Landscape and Visual – Composite and rendering analysis.

Feedback on the information supplied by the Applicant in document “Response by the Applicant on Landscape and Visual Matters” EN010122/D5/13.11

Figure 4.11: Indicative Access Track
Cross Sections (4.5m/6m/3.5m)

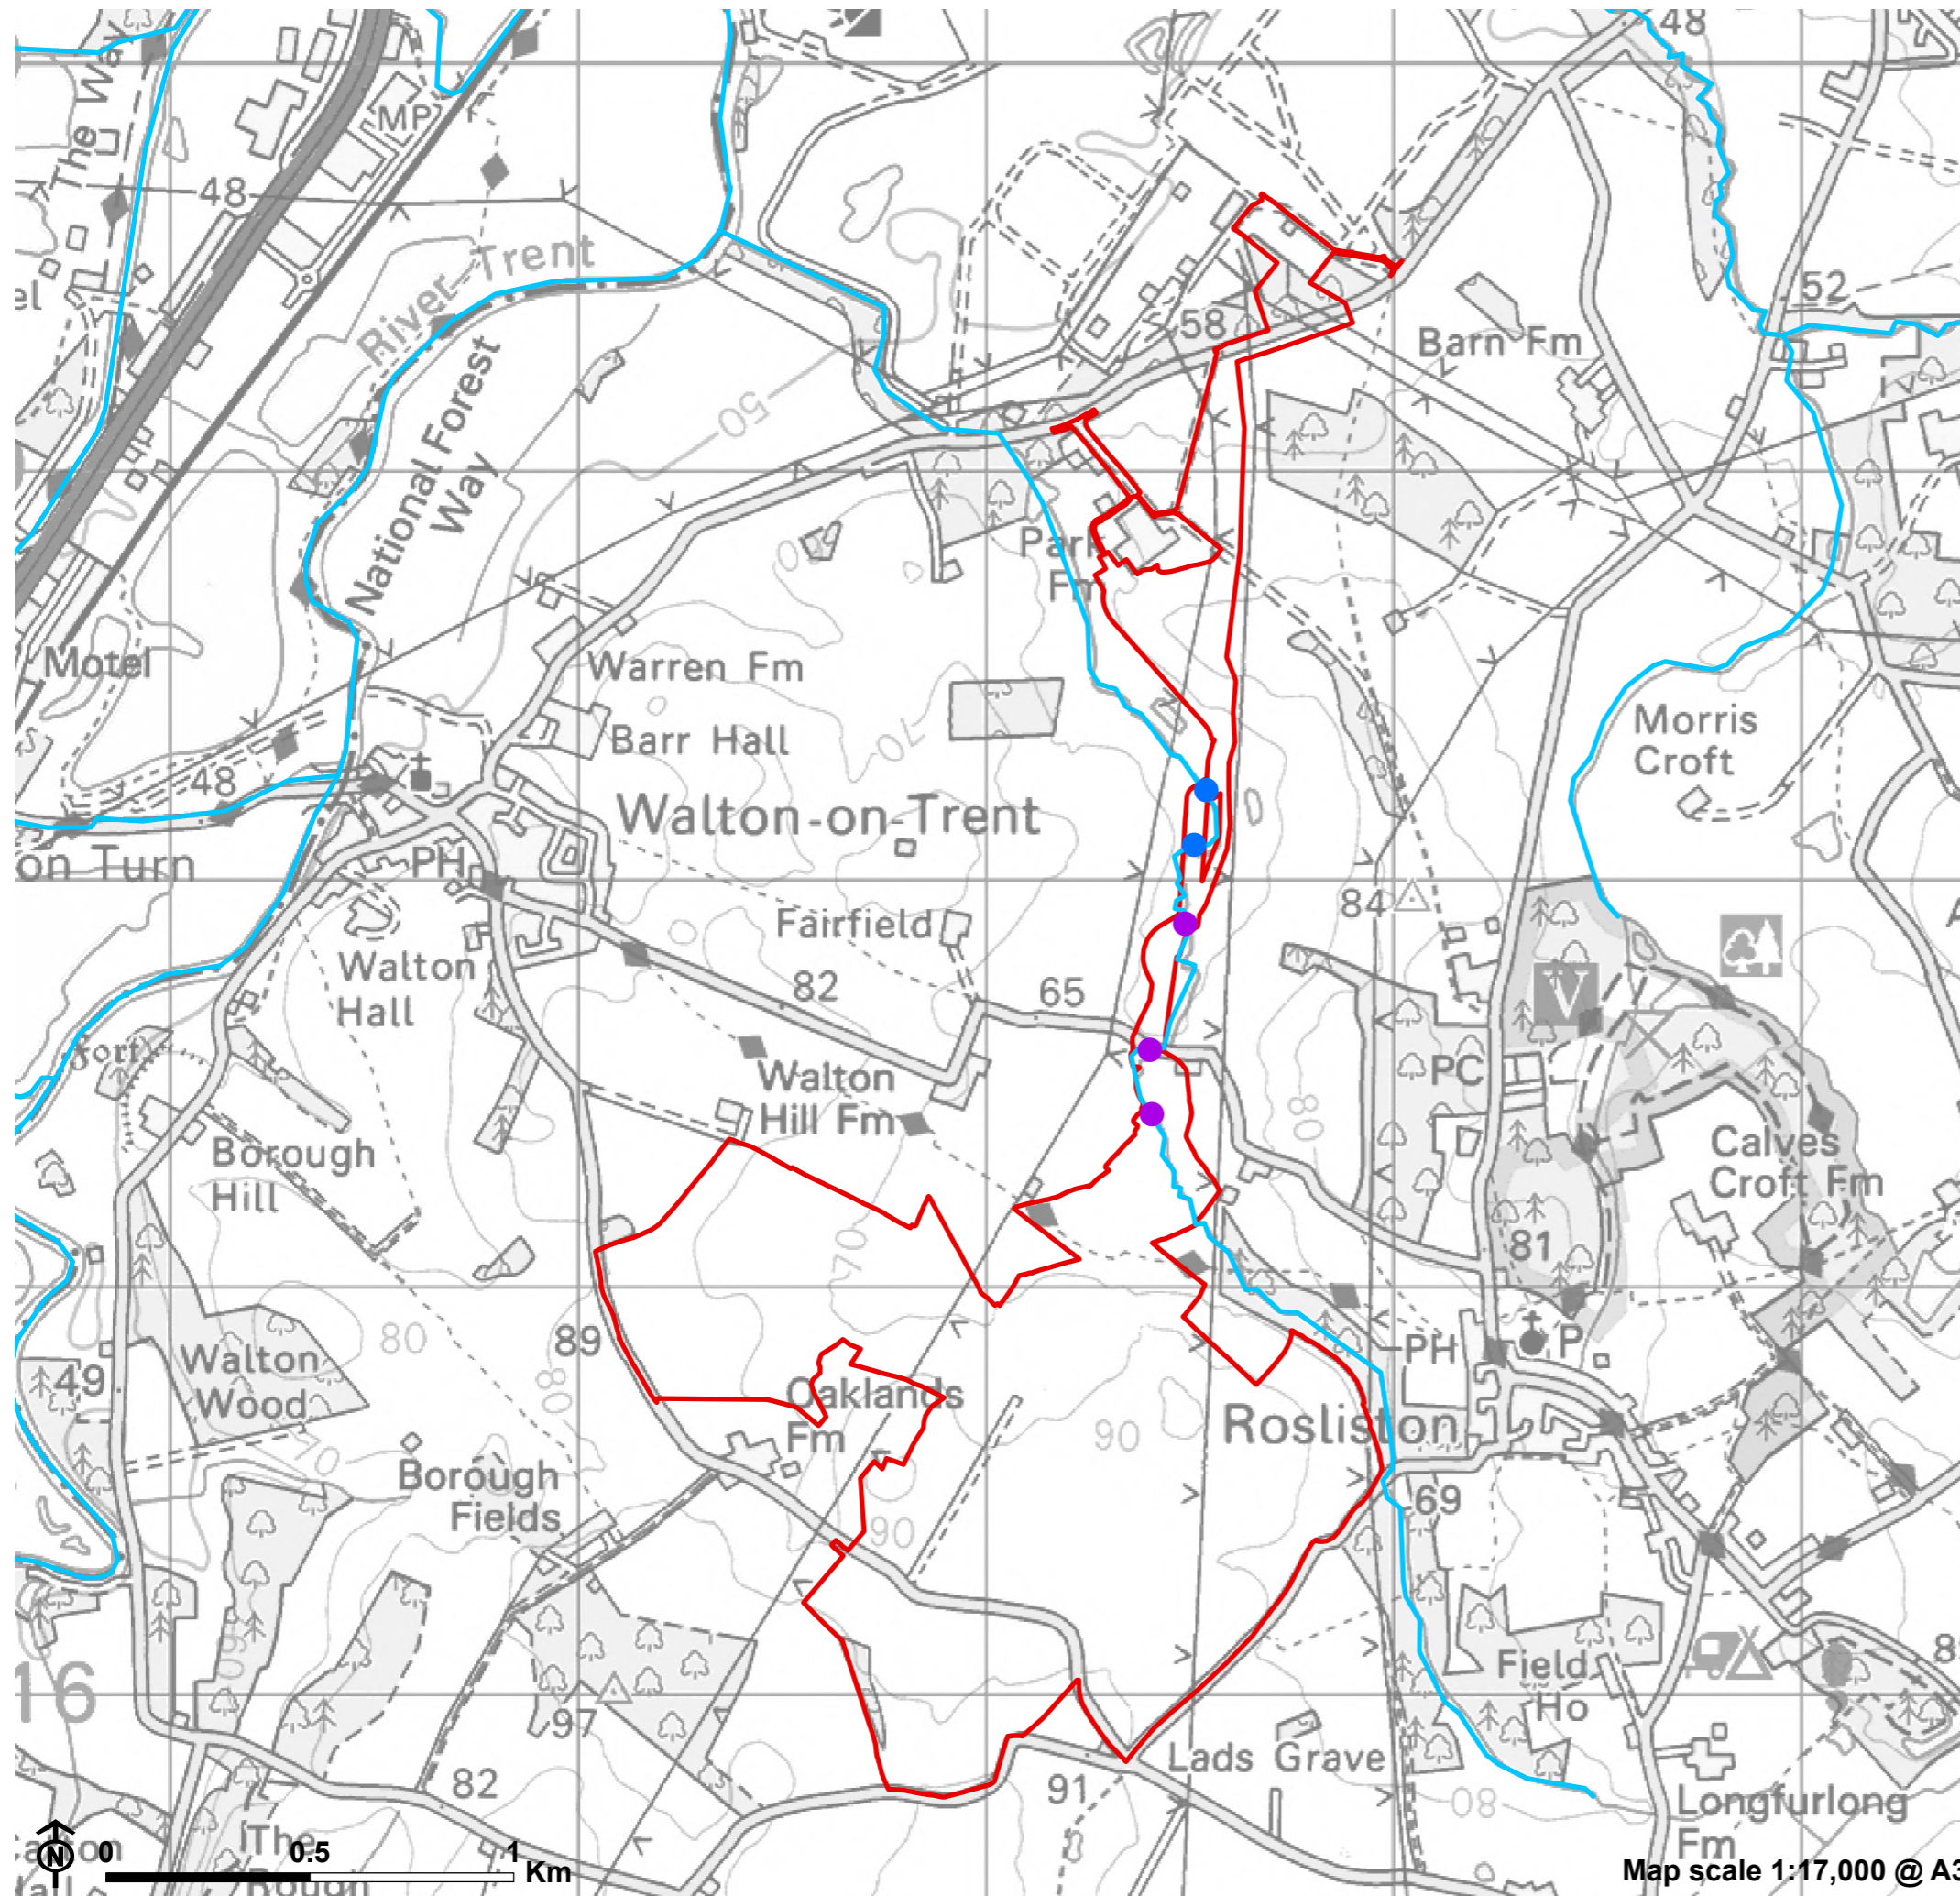
The on-site tracks will either be 6m or 3.5m wide. If this is to be a 3.5m track, then it needs to be shown as wider than the original track in the source photograph.
